Council has reviewed the amendments for Application No. SSD-17424905 (Pymble Ladies Collage – Grey House Precinct) at 20 Avon Road, Pymble. This objection is in addition to the submission opposing the Grey House Precinct development submitted by Ku-ring-gai Council on 6th December 2021.

1. Height and bulk of the building

Polychlorinated Biphenyls (PCBs) in older style florescent light fittings

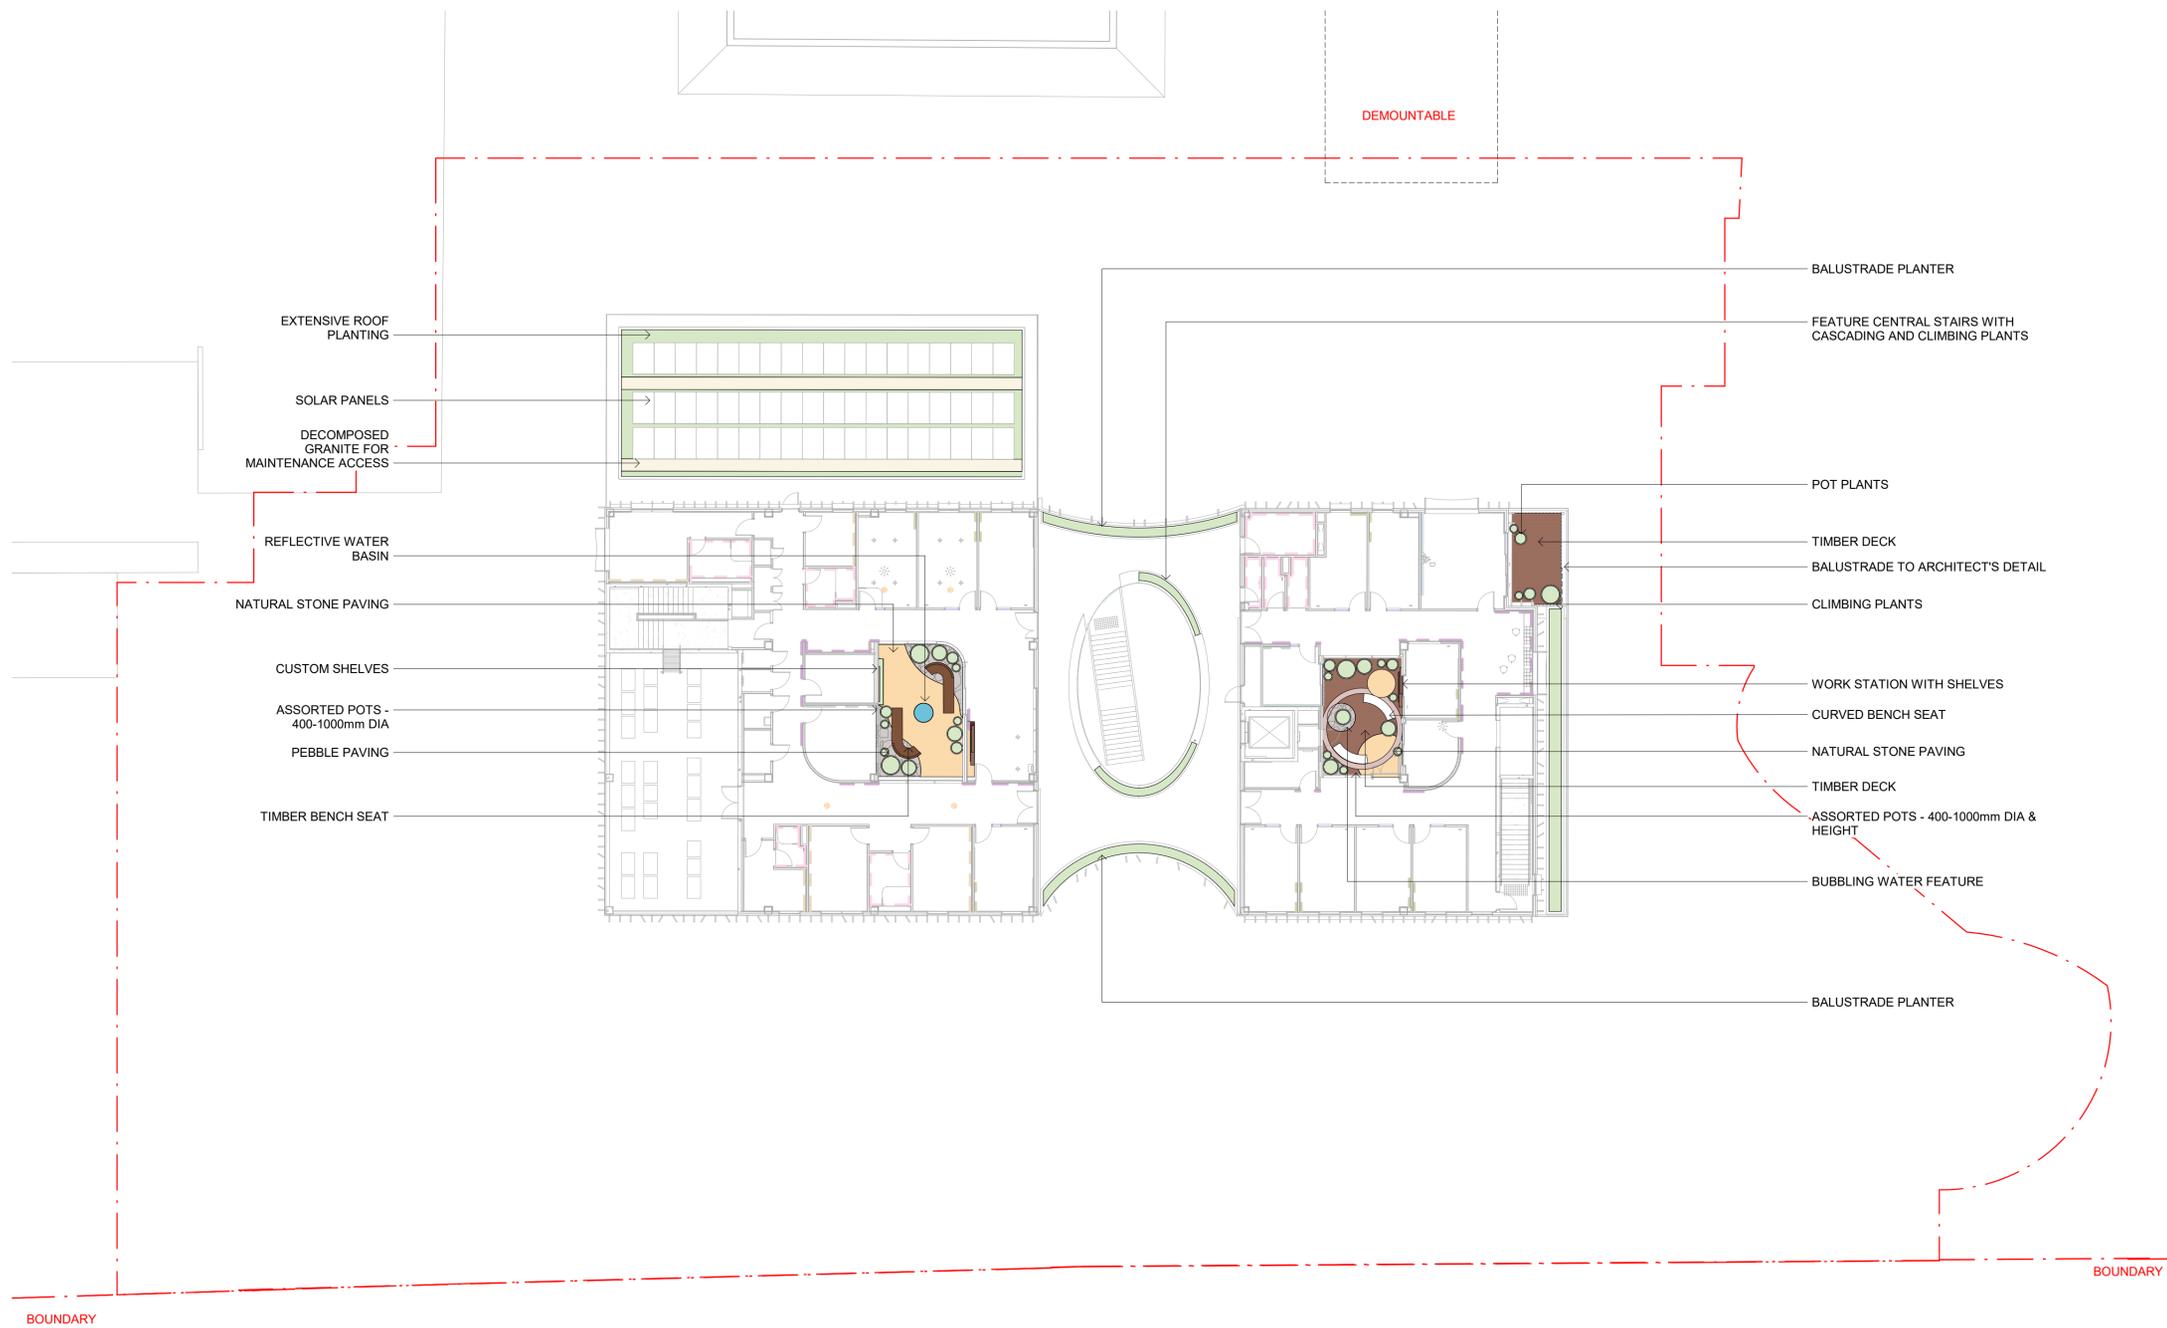
It is recommended that consideration be given to the relocating the top two or three levels of the building (Level 02, 03 and 04) towards the north-west and increasing the set back from the south-eastern (rear) boundary to minimise the visual bulk of the development as viewed from the adjoining dwelling houses, as shown in **Figure 1** below.
